Date: January 3, 2023

FROM: Margaret Haynes, NMDOT Assistant District 3 Traffic Engineer

SUBJECT: Chuze Fitness Traffic Impact Study
NM 45 and Central Avenue, southwest quadrant
Albuquerque, New Mexico

FIGURE 7a
Albuquerque Chuzo Fitness
Buildout (2022) Peak-Hour Traffic Volume

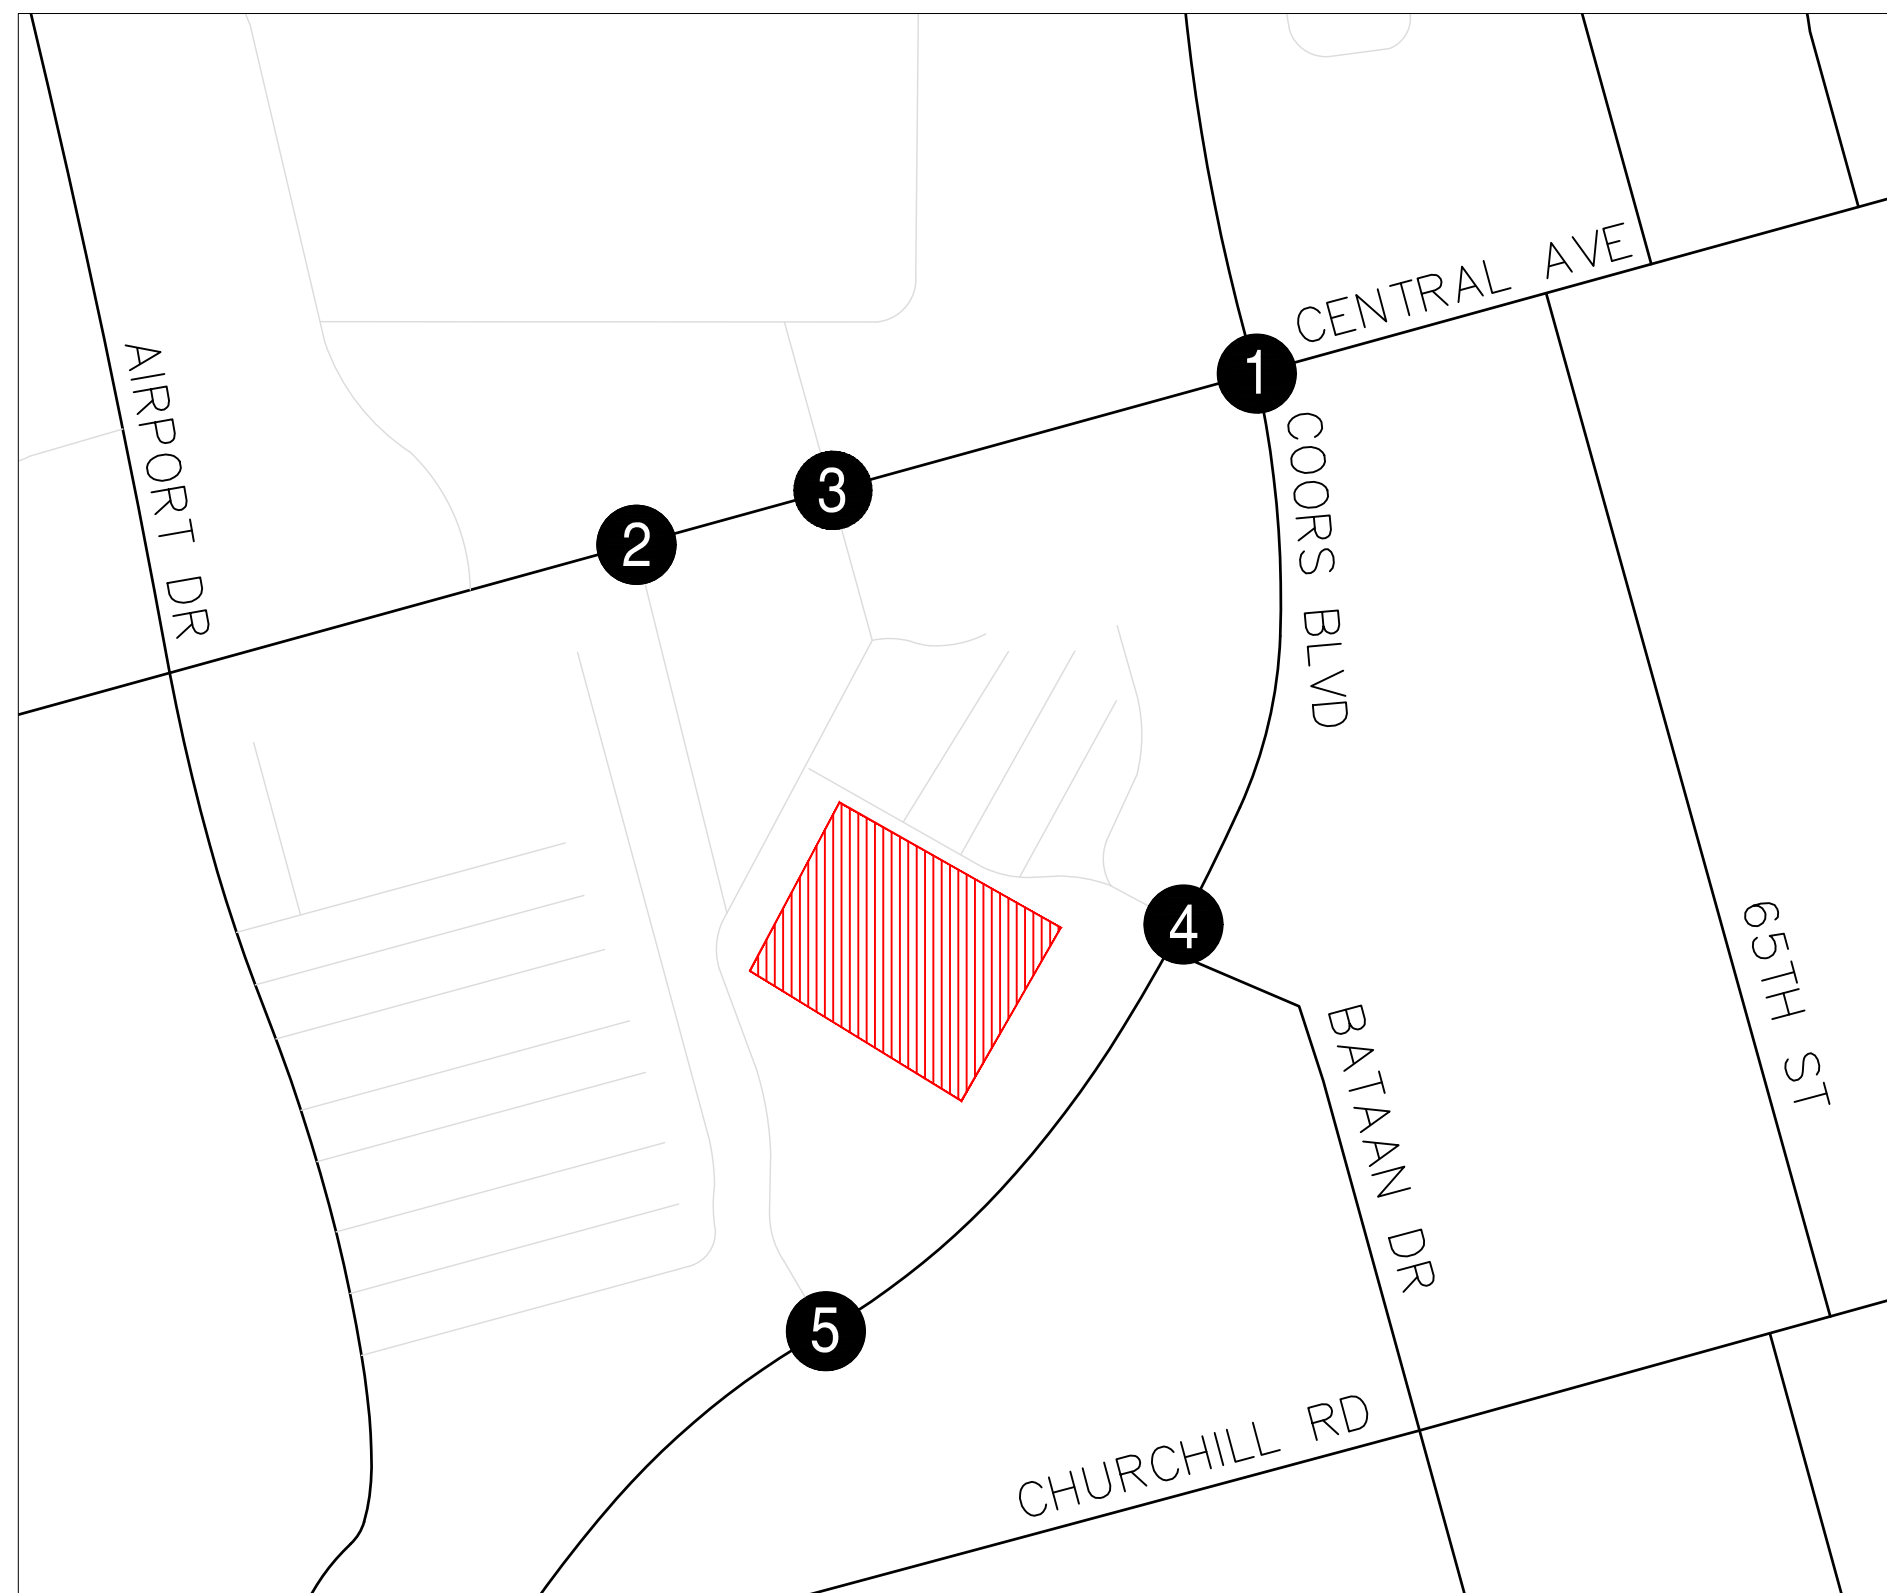
Page 25 – I presume that "2022 Total Traffic" means "2022 Full build" correct? I prefer the later name.
